# ENG-PUDSP21005-R3-PUDSP.pdf Markup Summary

**Subject:** Callout  
**Page Index:** 1  
**Date:** 4/15/2022 3:10:03 PM  
**Author:** Ryan Howser  
**Color:** ■  
**Layer:**  
**Space:**  
**Page Label:** [1] WB PUDSP 3.10.22-Cover

SHEET TITLE: WEST AREA DEVELOPMENT PLAN

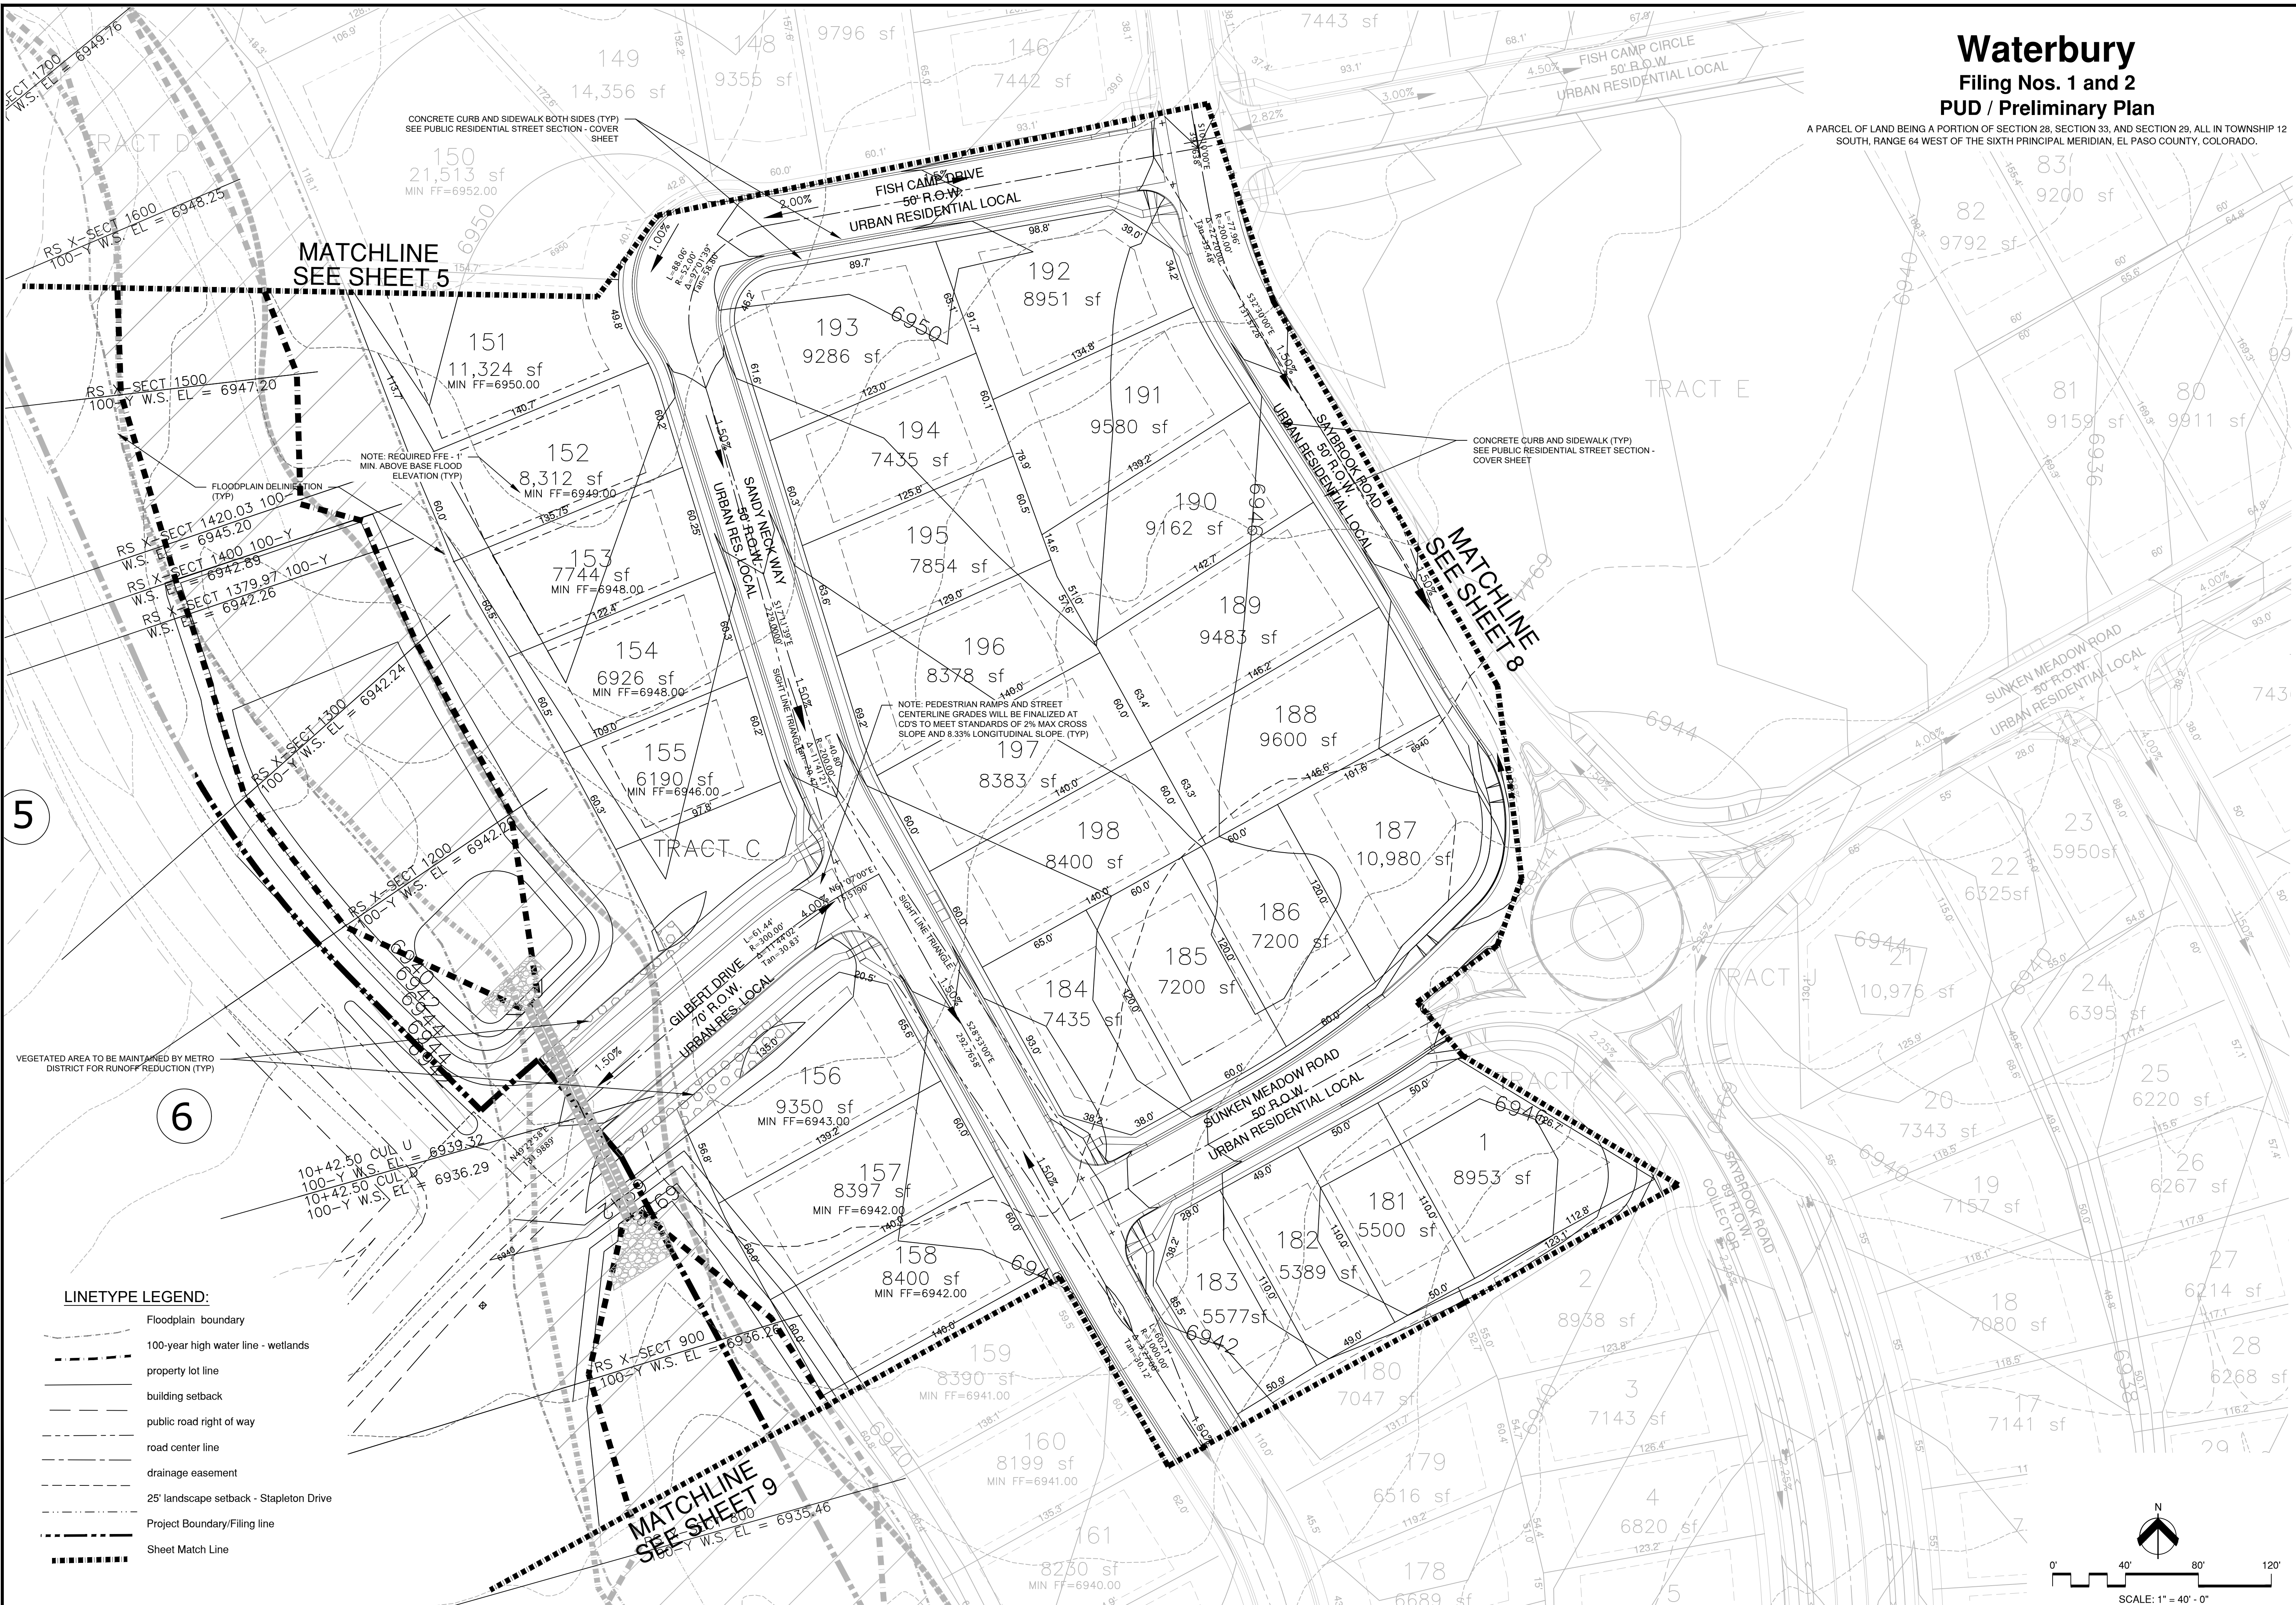
Line needs to extend to ROW

Fix overlapping text

corrected

corrected

**SHEET TITLE:**  
EAST AREA DEVELOPMENT PLAN

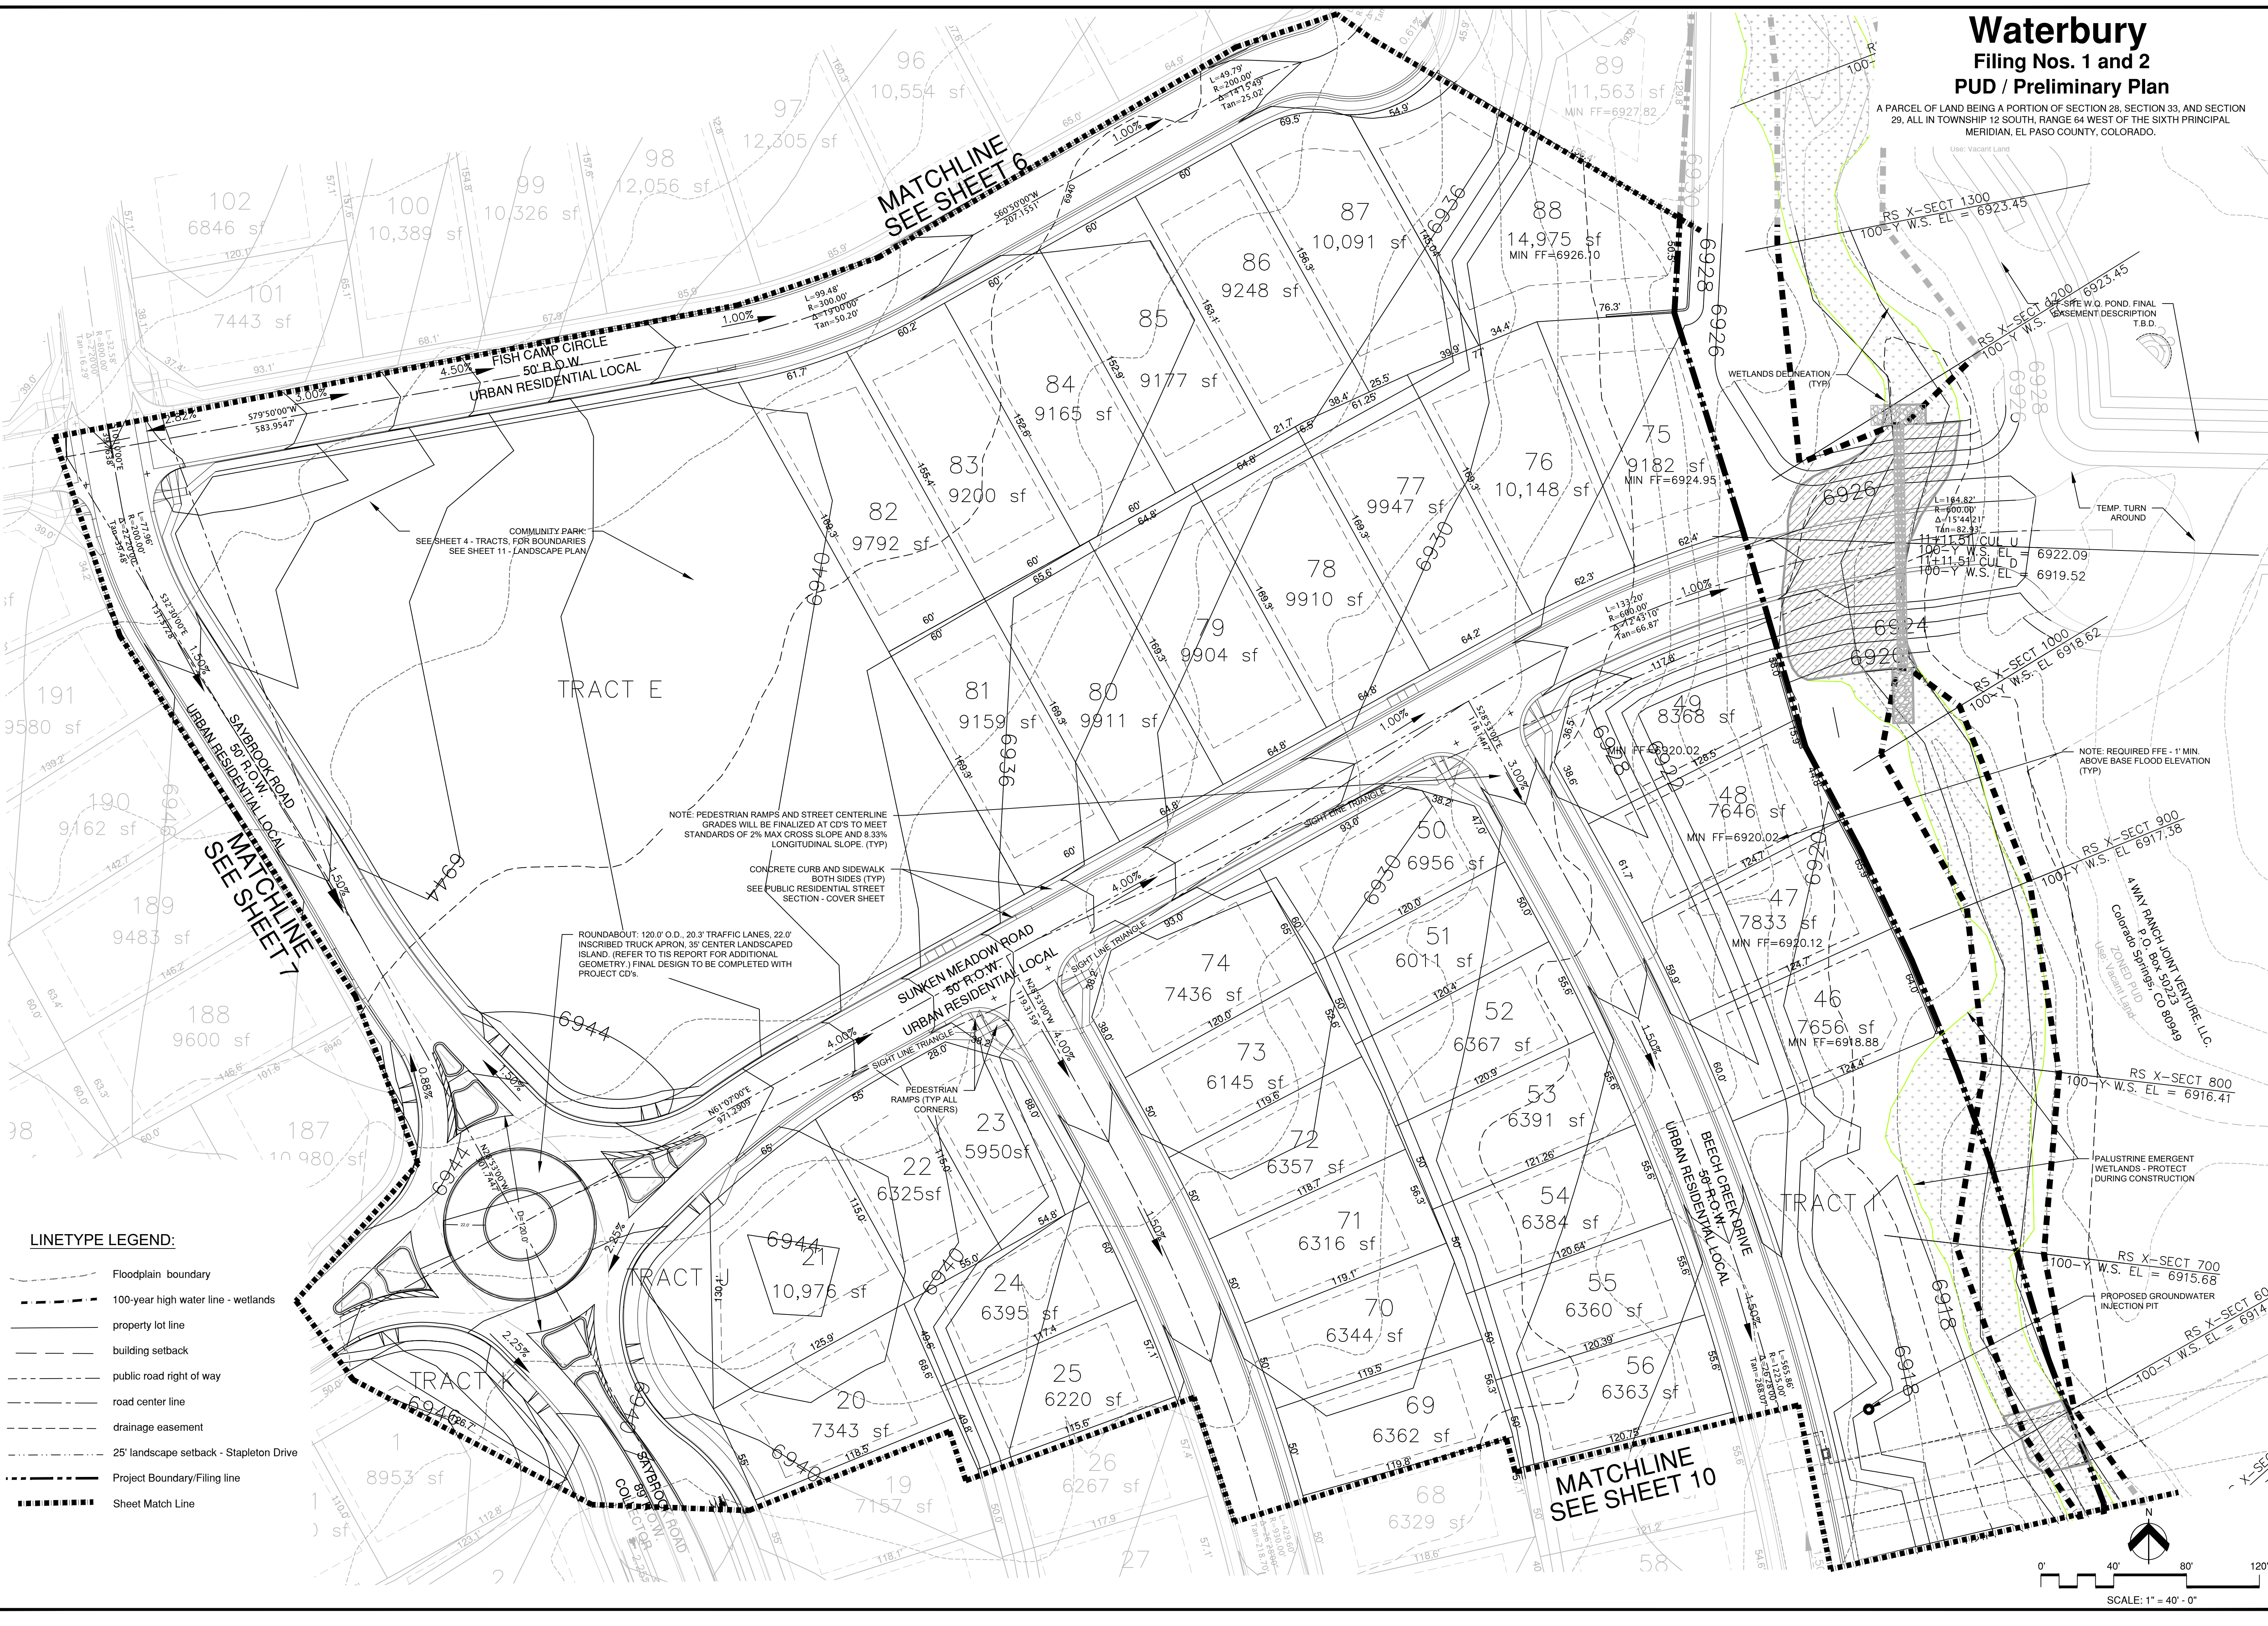
Missing sight triangle lines

Can't read all of note

Label temporary turnaround

Add note describing size of roundabout (XX' inscribed circle with XX center island and truck apron all based on TIS RAB revisions), final design TBD with CDs. Revise the layout per the TIS.

Label tract boundary distances and SF (all tracts)

added

corrected

added

added/corrected

note on Community Park added to refer to Sheet 4: Tracts
